Department of Transportation

December 4, 2022

RE: Solace at Cimarron Hills Phase - No.2 - SF2232_Multifamily (Site Development Plan, Rezone and Final Plat amendment)

Arthur Gonzales
CDOT R2 - Access Manager

OVERALL SITE PLAN

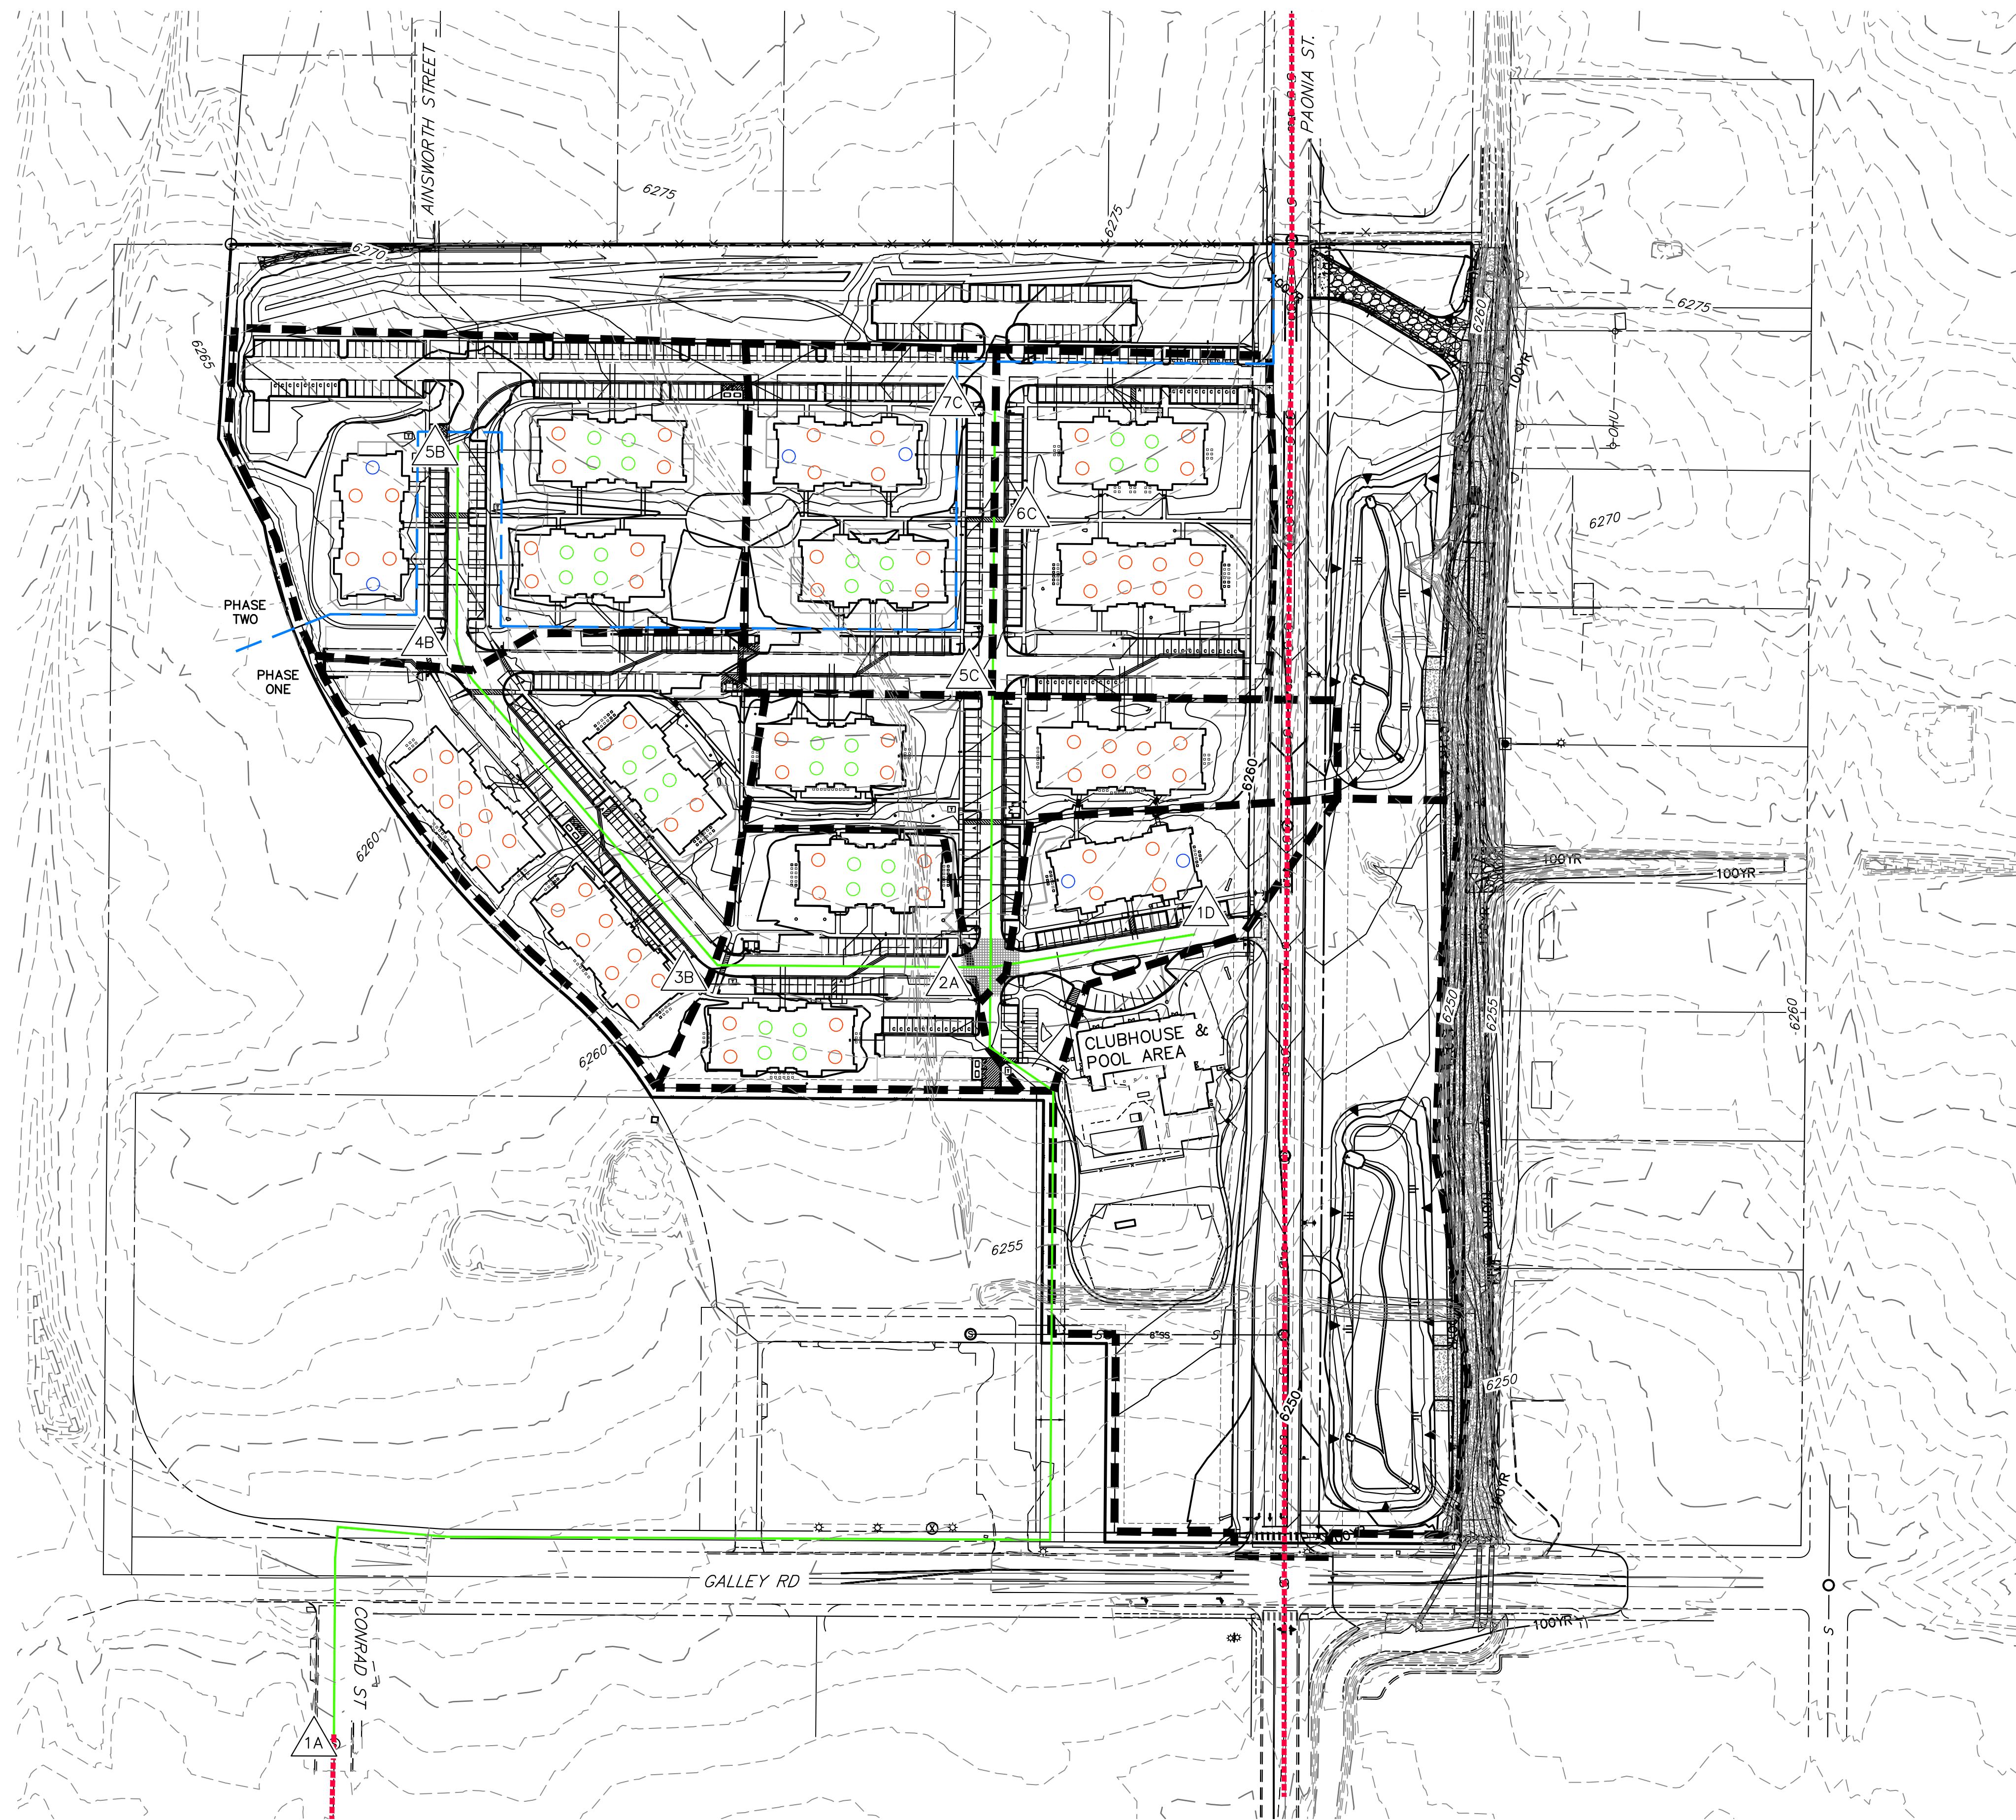
- SH21/Powers Blvd. is Categorized as FW (Interstate, Freeway Facility). Access is to be gained from local roadways and no direct access is to be gained from SH21/Powers Blvd. to the developmental site. Access is to be gained via the intersections with SH21/Powers Blvd. at Galley Rd. to the south of the development and the right in/right out east Omaha Rd. to the north of the site and then onto Paonia St.

- Significant traffic is anticipated to use the intersections at SH21/Powers Blvd. and Galley Rd. and at Omaha Rd. Two CDOT Access Permits will be required for this development to document the additional traffic and utilization of SH21/Powers Blvd. connections.
